Subject: Comments from KC PROW - 2025/91001 and 2024/93227

Comments from Kirklees Council PROW Team

2025/44/91001/E

Discharge of details reserved by condition 5 (access re-surface) on previous permission 2020/94345 (APP/Z4718/W/21/3289729) for erection of 5 dwellings

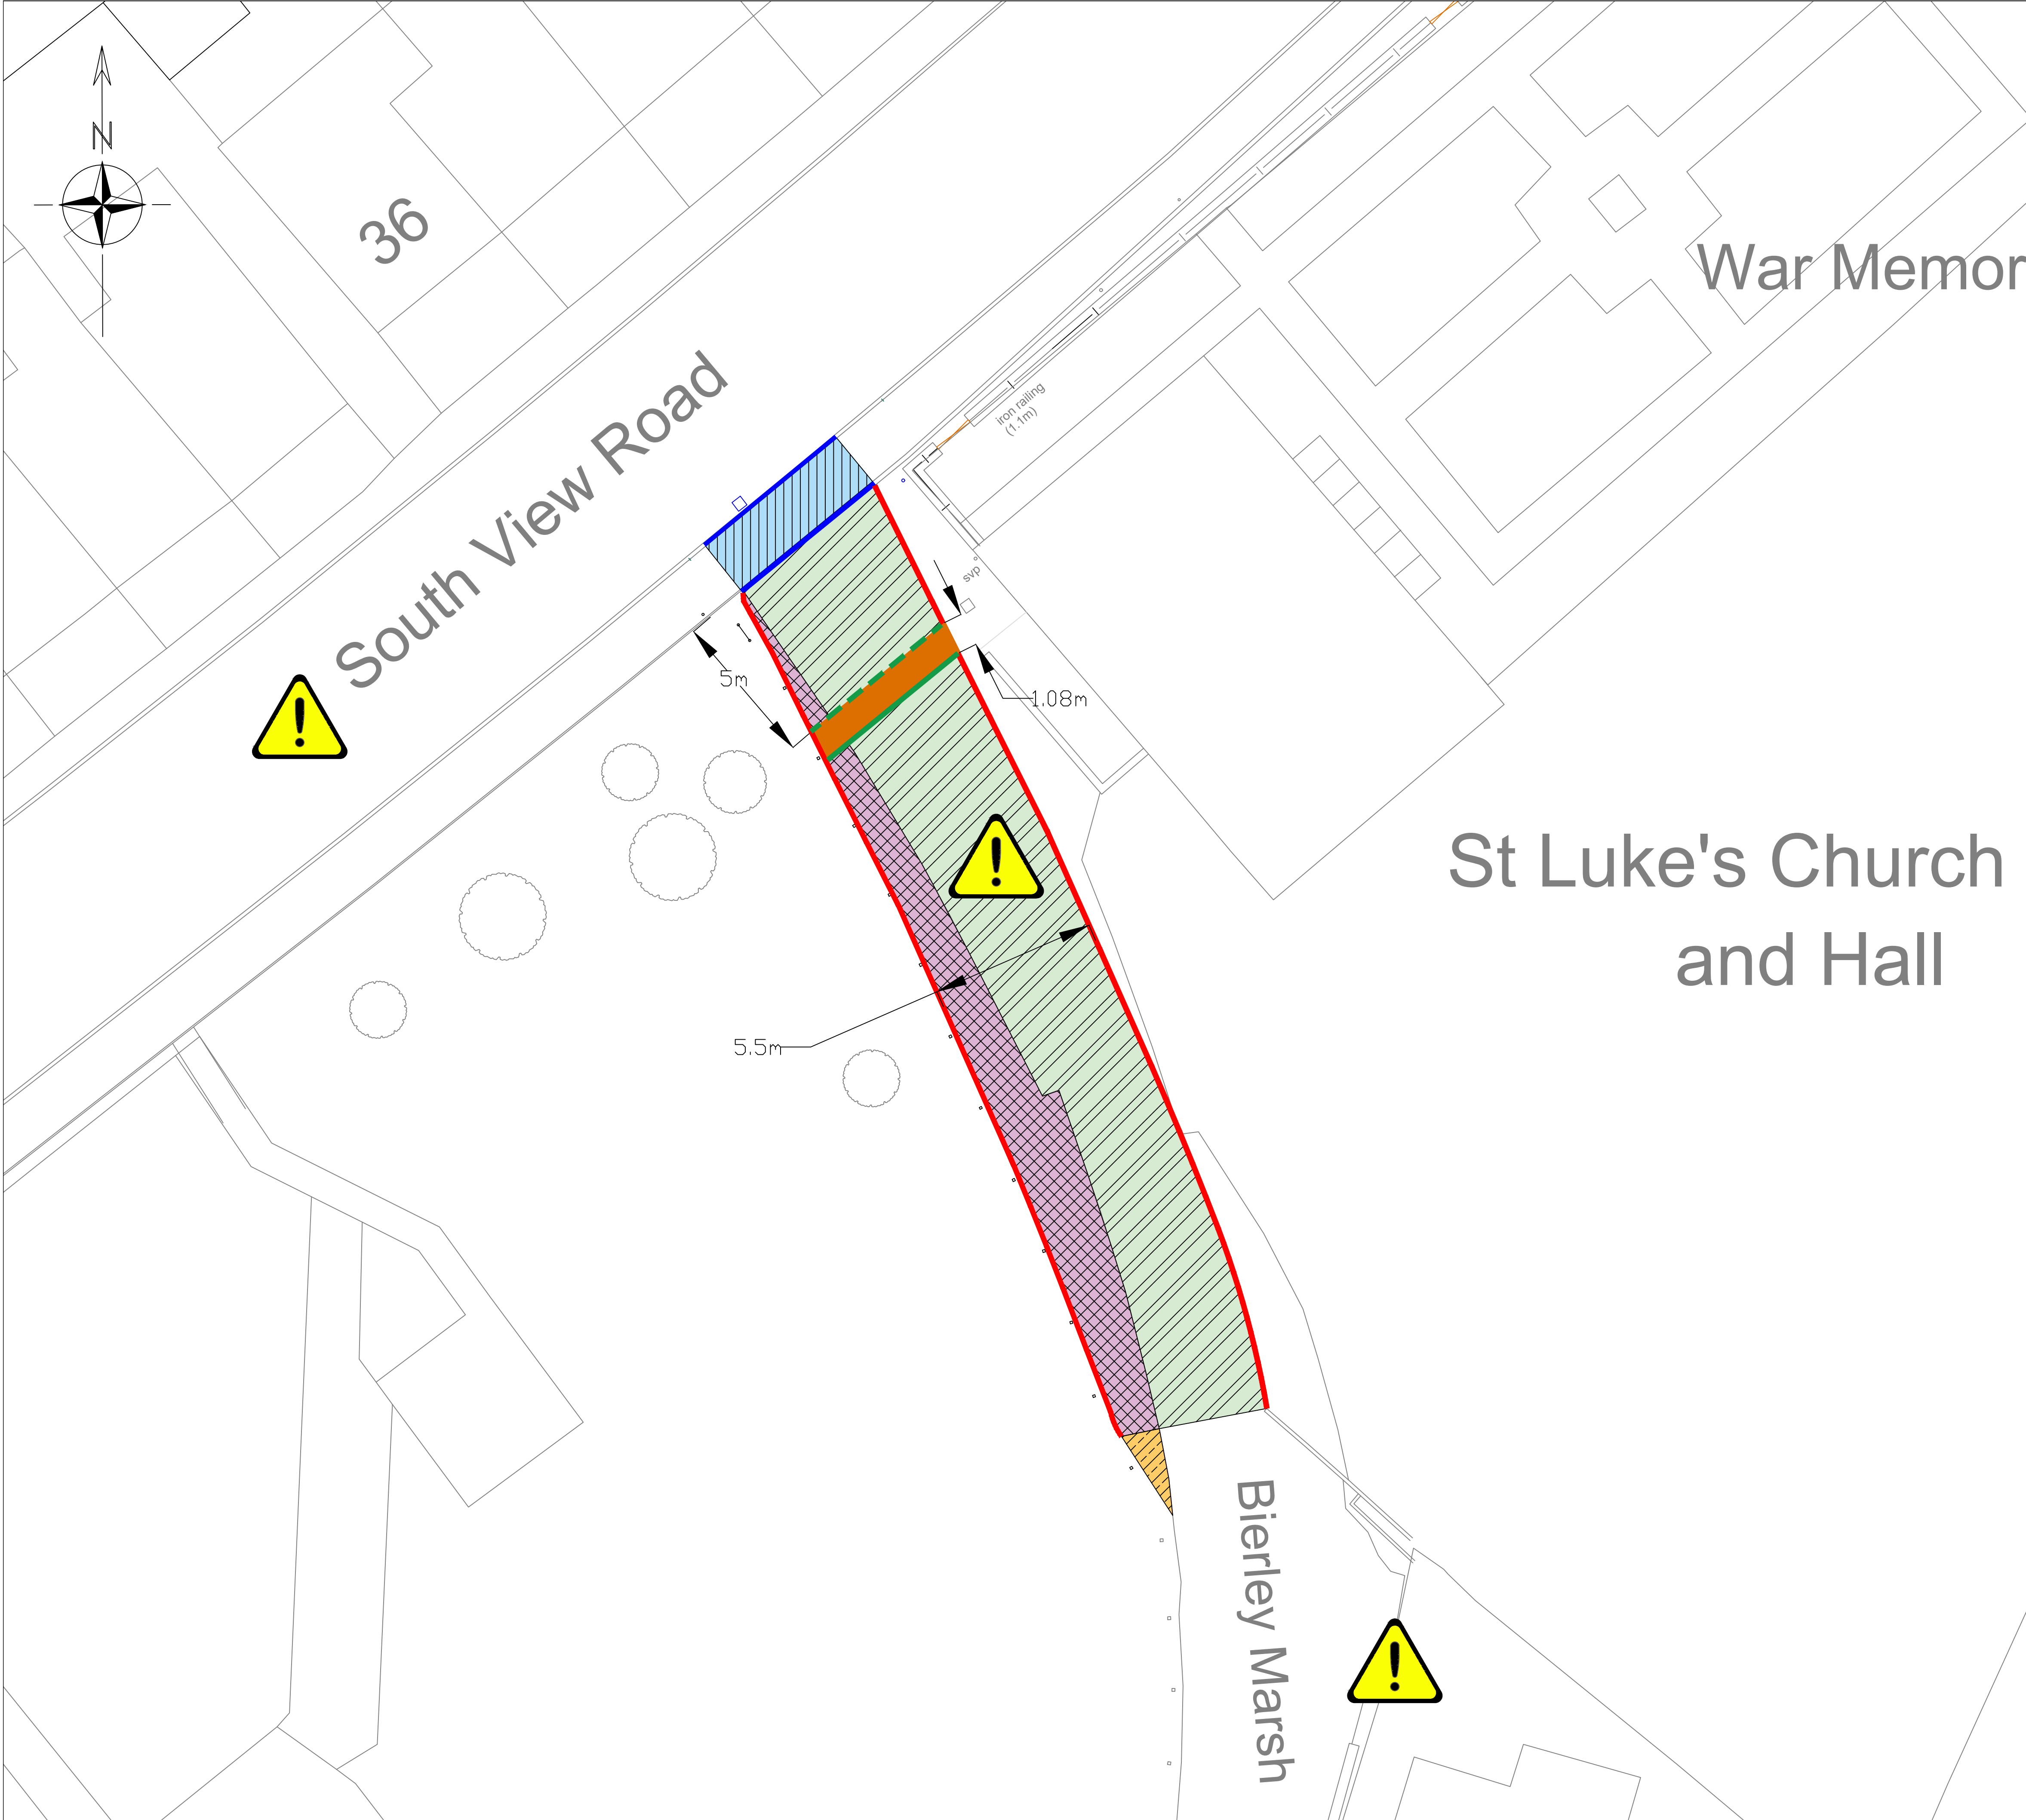
Public footpath SPE/6/20 runs along the access road (part of Bierley Marsh) that will serve the development. In addition to carrying a public footpath the road currently provides vehicular access to various existing properties. The existing access road along which FP SPE/6/20 runs currently has a sealed surface. KC PROW does not object to the resurfacing of SPE/6/20 in the manner shown on drawings 104 F, MCB/24/018/0701 and MCB/24/018/0201. However, for the benefit of the applicant, other landowners who take access over Bierley Marsh, and officers in other teams, the following additional observations are made regarding the widening / resurfacing of Bierley Marsh.

Footpath SPE/6/20 abuts East Bierley Village Green. That is registered common land forming part of CL222 (Toftshaw Moor). The common land is subject to a public right of air and exercise under s193 Law of Property Act 1925. The land is owned by Kirklees Council having been conveyed to a predecessor authority in 1934 for use as a 'green'. The land is vested with Parks & Greenspace . The registered common land does not appear to included public footpath SPE/6/20, or have historically included the land on which the original access road ran (barring any presumed sub soil ownership to the centre line of the way). The land provided for the use us a 'green' may also be subject to restrictive covenants regarding its use.

Over time a strip of land on the east side of the common land, where it abuts the west side of SP/6/20, had become used informally for the parking of vehicles. At some point this strip has been resurfaced with asphalt and / or gravel. Posts were erected on the grass to prevent further encroachment by vehicles on to the village green. The current proposal shown in drawing MCB/24/018/0701 and other drawings includes proposed resurfacing, for use as part of the access road to previous approved development (2020/94345), of the strip of Kirklees-owned common land as far west as the existing line of posts. Consent from the vesting service would likely be required for any works, also in respect of the granting of an easement.

The consent of the Secretary of State may be required, under section 38 of the Commons Act 2006, to carry out works including resurfacing of part of the common land. If appropriate the owner of the land may make an application to the Secretary of State for deregistration / exchange of common land.

Matters relating to private access rights, landowner consent, and consent from the Secretary of State in respect of common land, are all matters for the developer to address but which fall outside the planning application process.
